From: Anna Appleton
Sent: 06 March 2019 14:59
To: Planning.Responses
Cc: Simon Davis
Subject: RE: Planning Consultation on: BR/39/19/PL

BR/39/19/PL - Application for Variation of Conditions following the grant of Planning Permission BR/240/16/PL relating to Condition 2 & Planning Permission BR/331/17/PL relating to condition 1 - approved plans

Site Address: Butlins Upper Bognor Road Bognor Regis PO21 1JJ

title: Elevations - Sheet 1

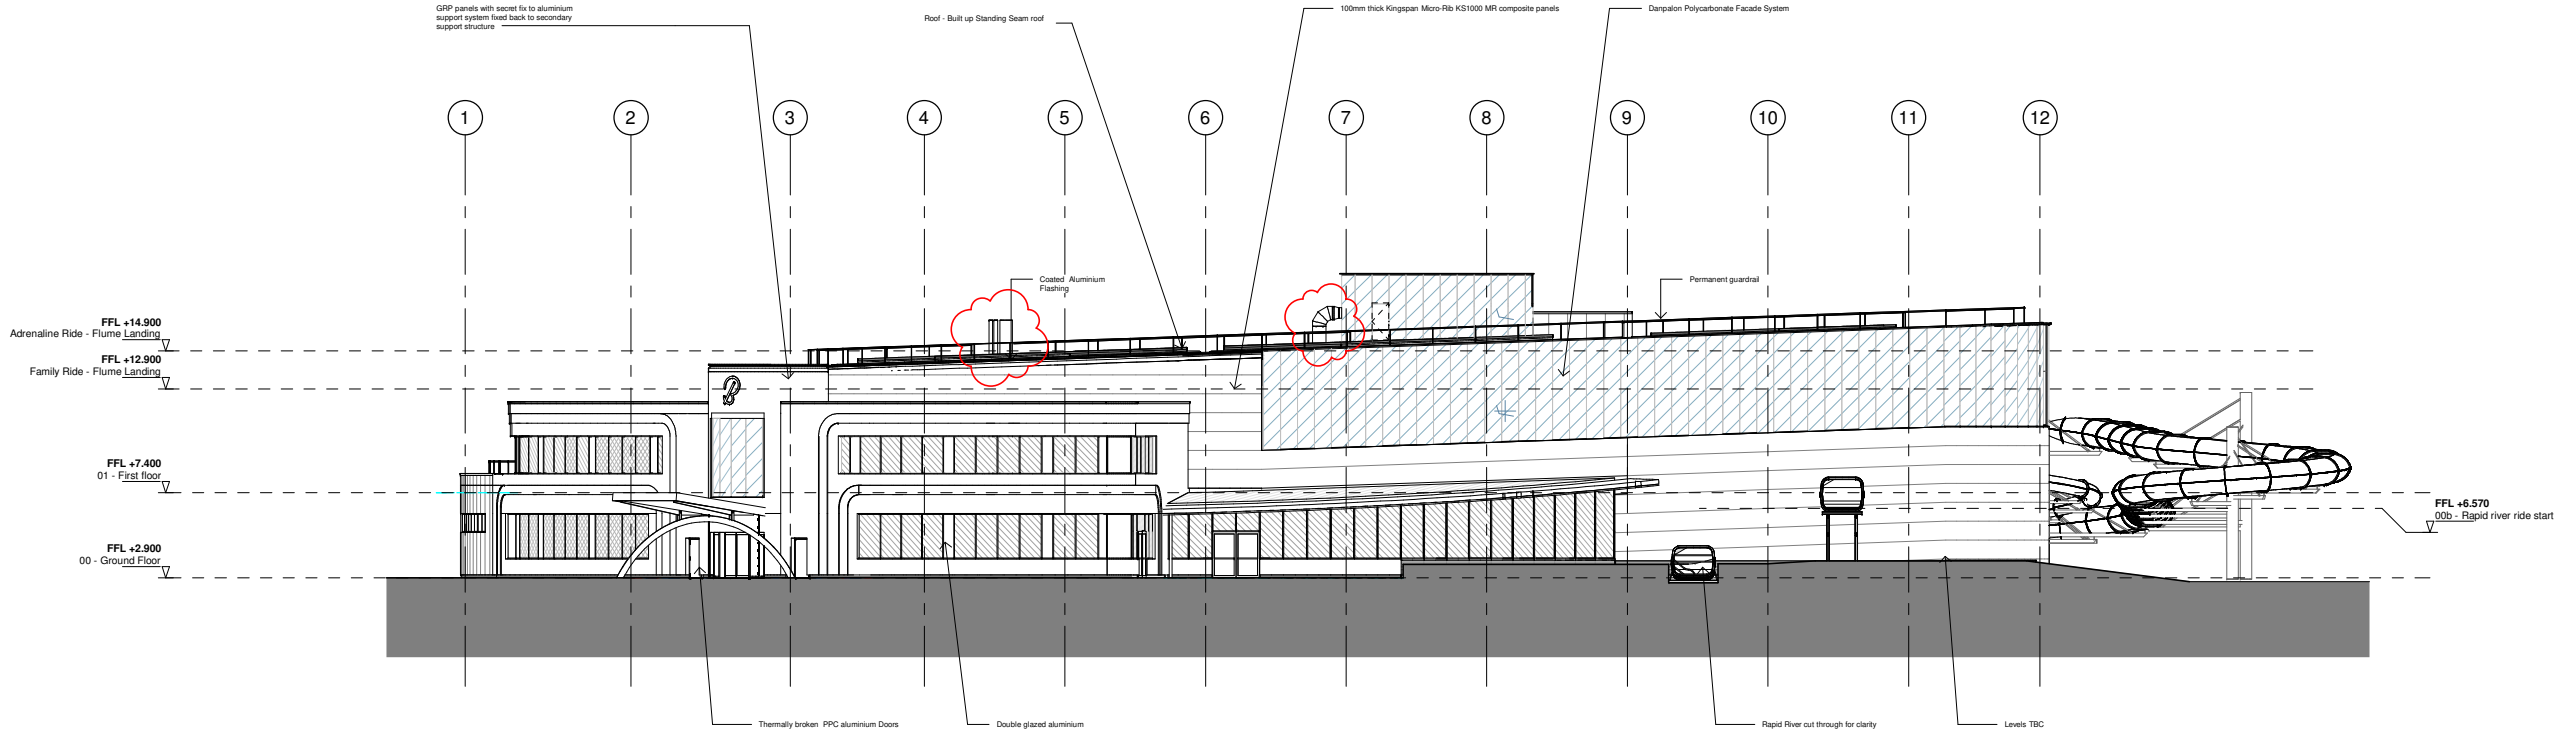
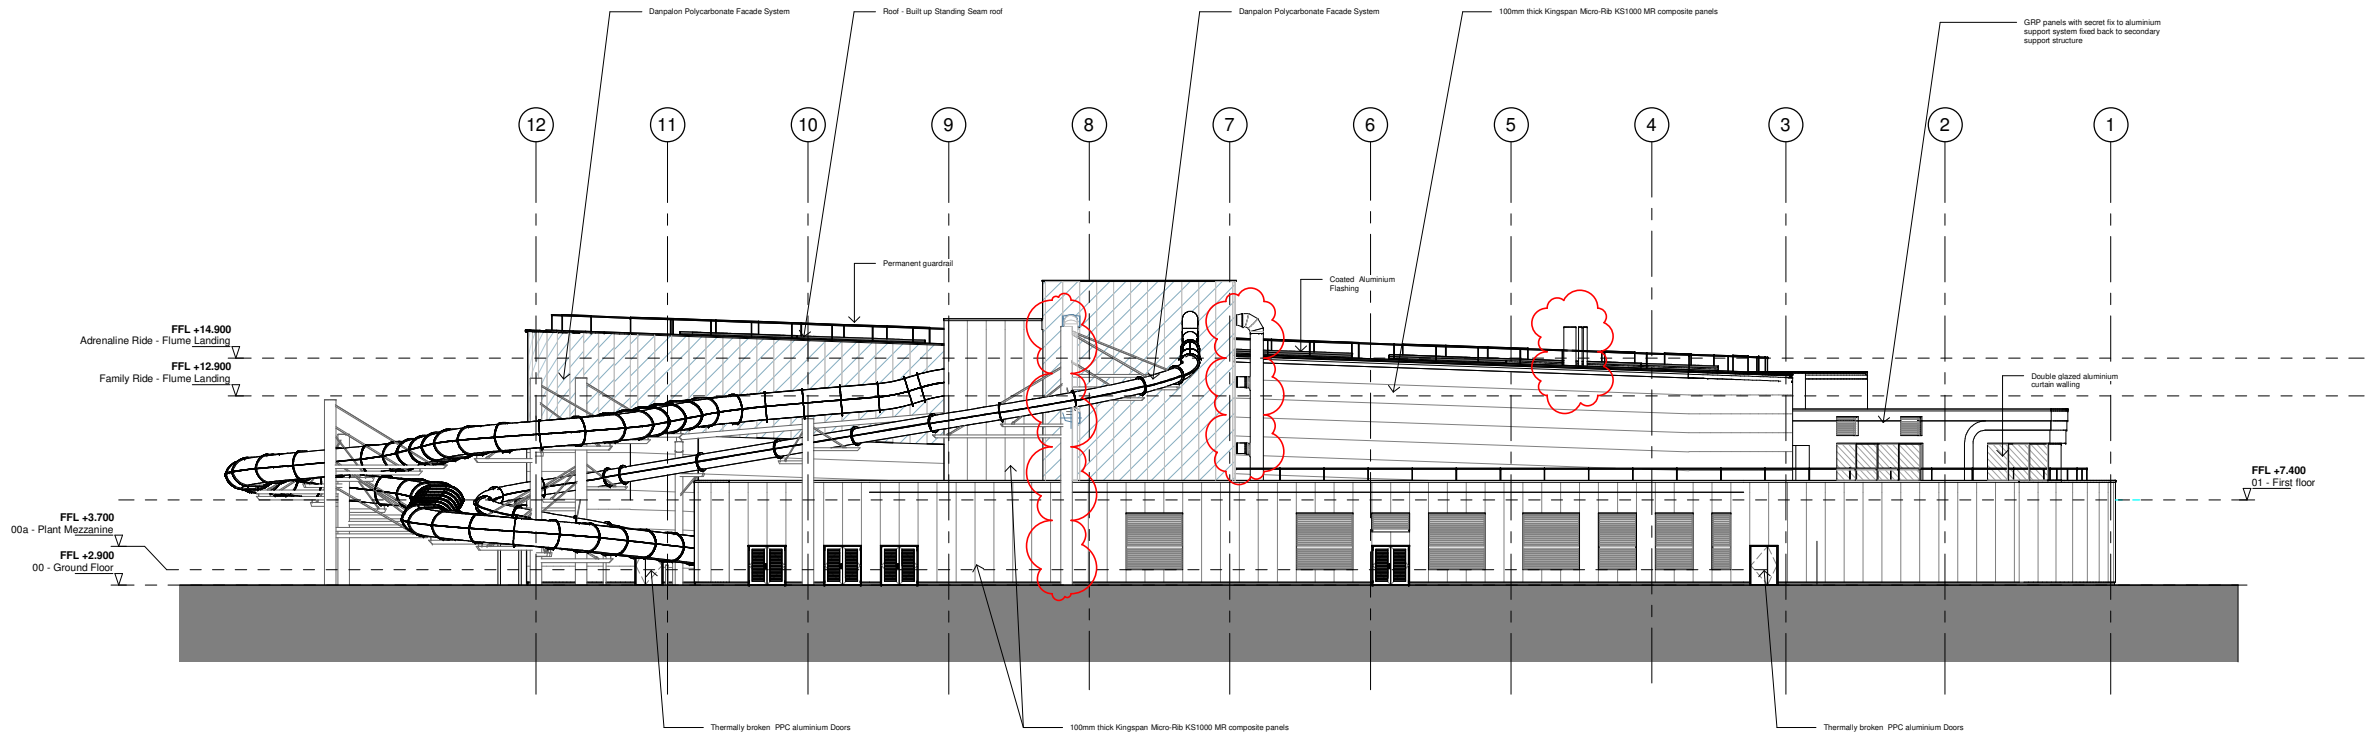
I note from the covering letter submitted with the application that it includes amendments to reduce the height of the flume, adjustments to the design of the rapid river and addition of louvres. They have stated that the louvres will have no impact on the acoustic performance of the building. However, I would request that the applicants also ask their acoustic consultant to confirm that the amendments to the flume height and the rapid river design will have no adverse impact on the acoustic environment. If this is the case then environmental health would have no objection to the amendments.
